Easterling Consultants LLC

RE: I40 South and Unser Mini DMP

Engineers Stamp Date 7-14-14 (K09D026)

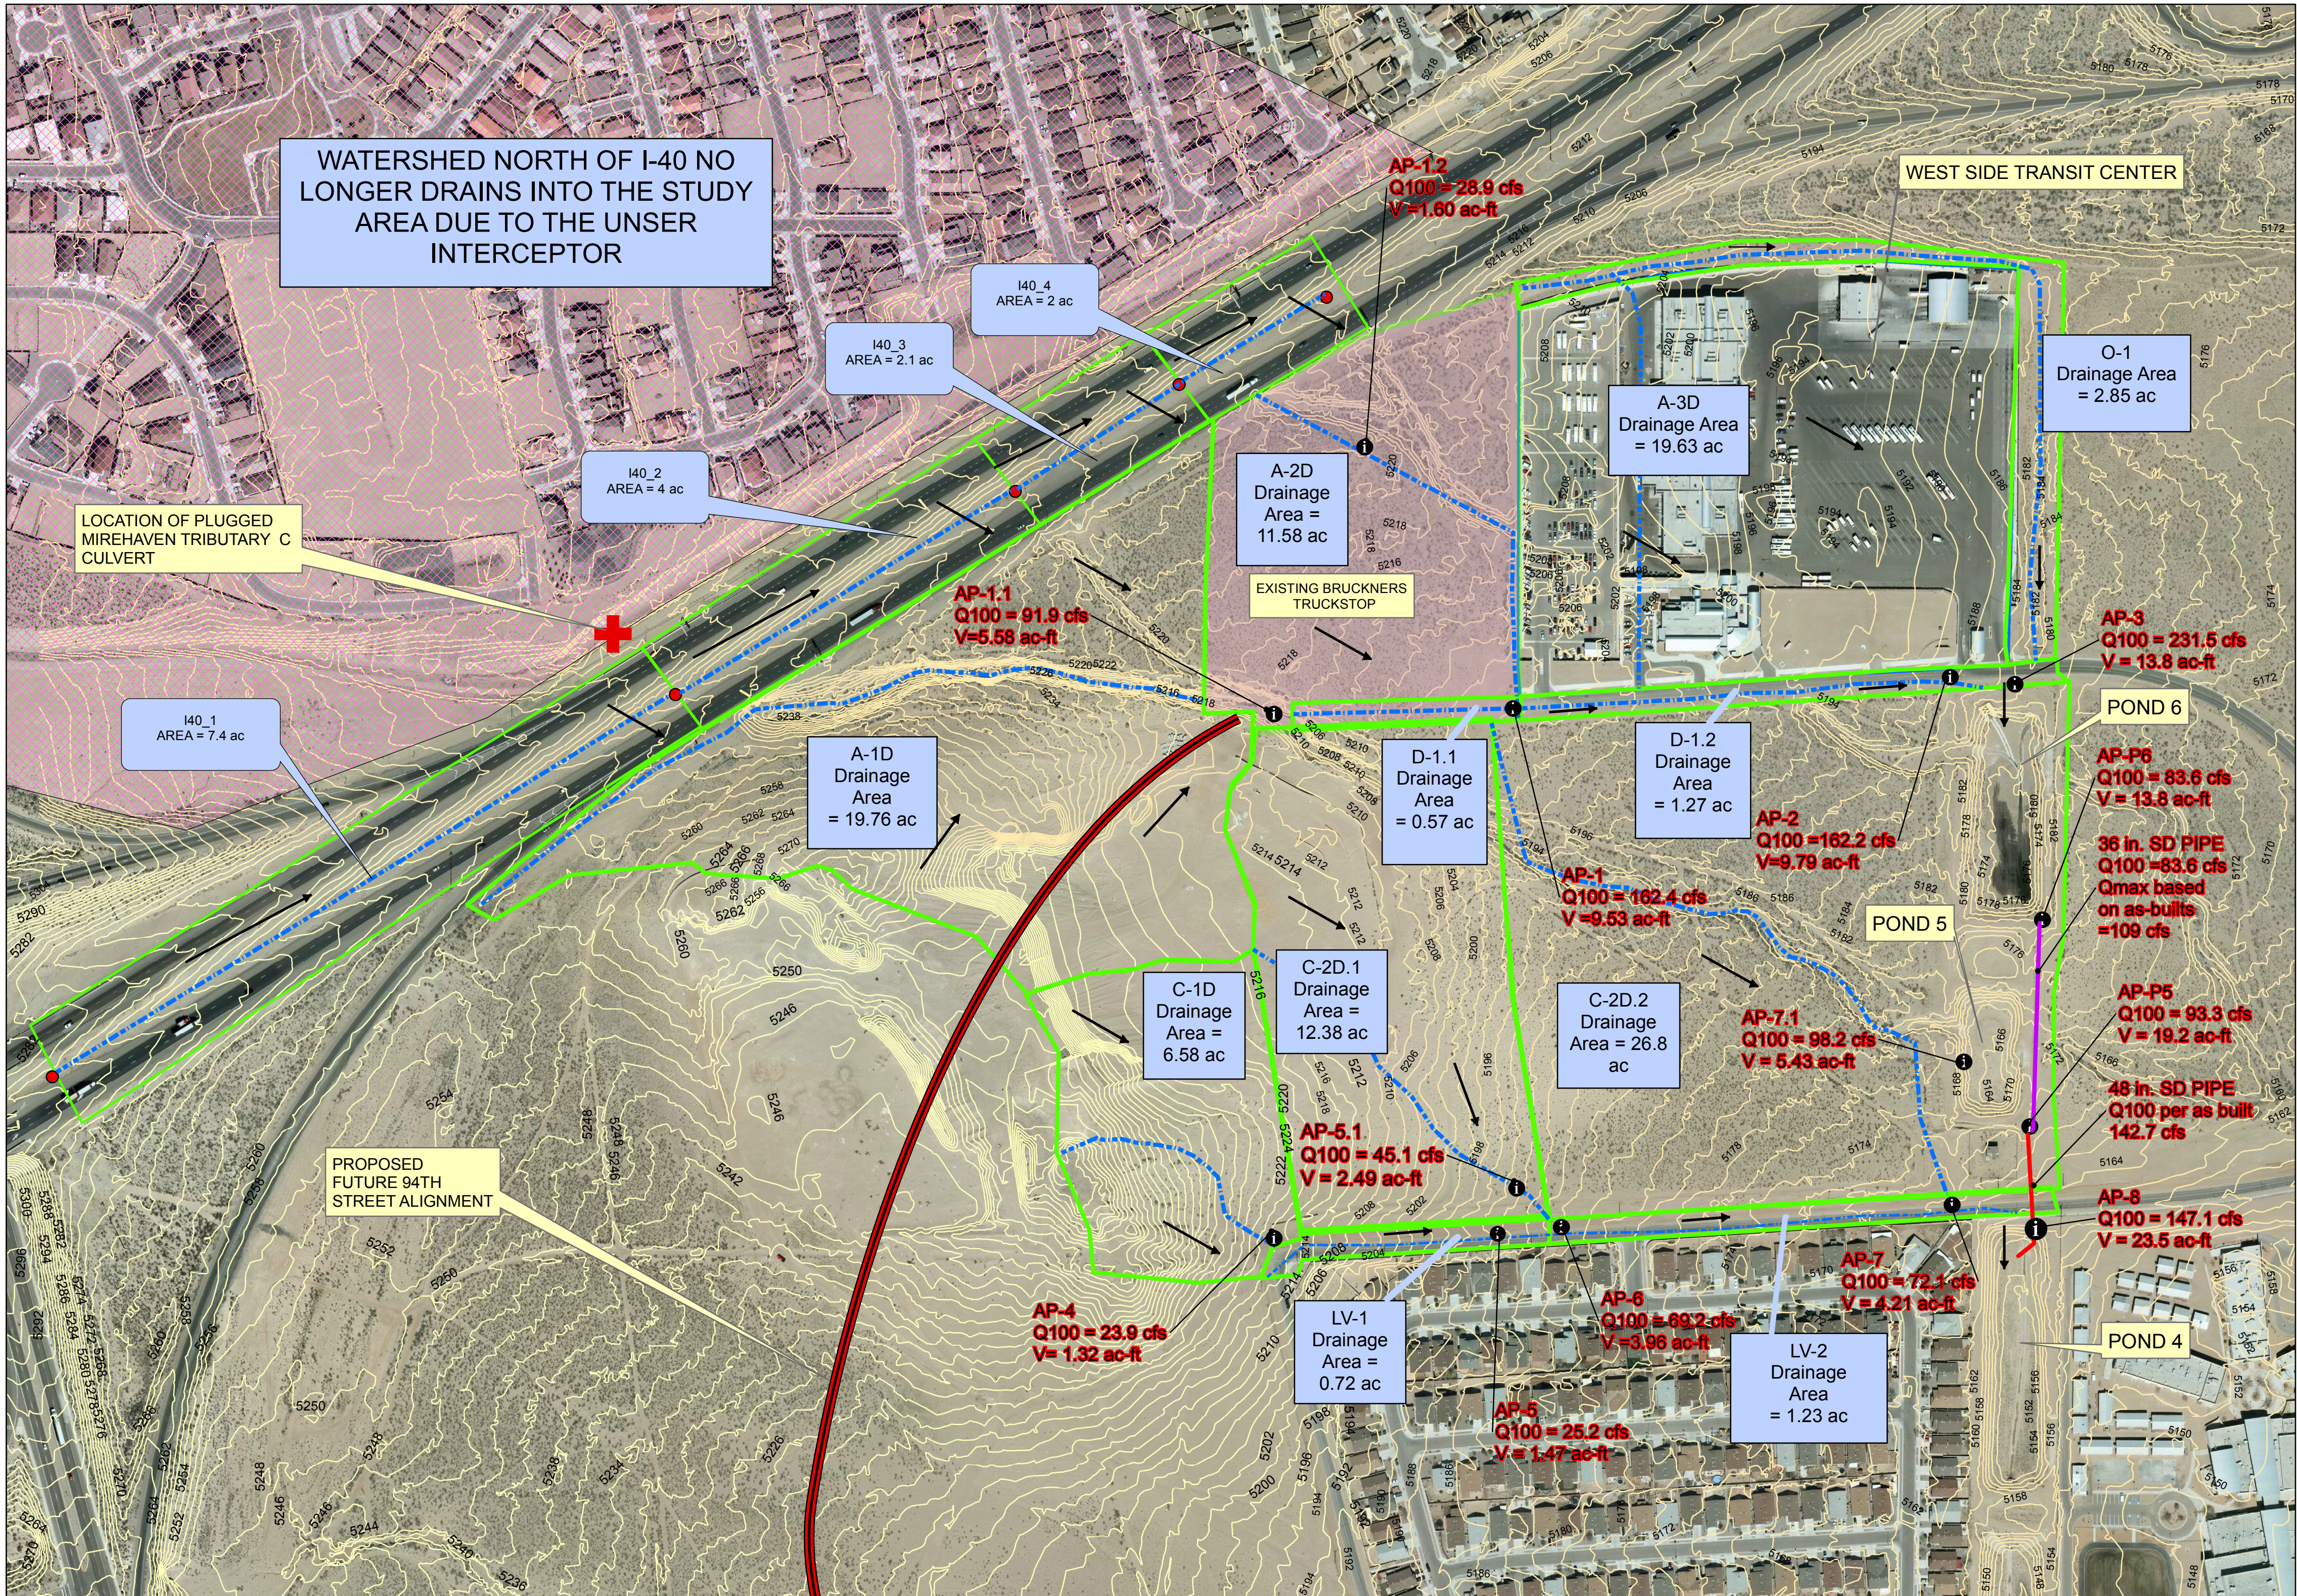
5. The freeboard for Pond 6 is shown as 0.4 feet. Proposed runoff should be reduced to increase the freeboard to 1.0 feet.

Based on our conversation, we agreed that imposing discharge restrictions on subbasin A-1D would be unfair as the other subbasins that have already developed have already taken more than their fair share of discharge capacity into Pond 6.

Secondly, the model simulates subbasin A-1D at a curve number of 90 with 90% imperviousness. The basin will unlikely develop as such, which makes the runoff results very conservative. From a hydrological stand point, Subbasin A-1D can't become impervious enough to generate enough runoff in order to overwhelm Pond 6 therefore, no modeling changes were made.
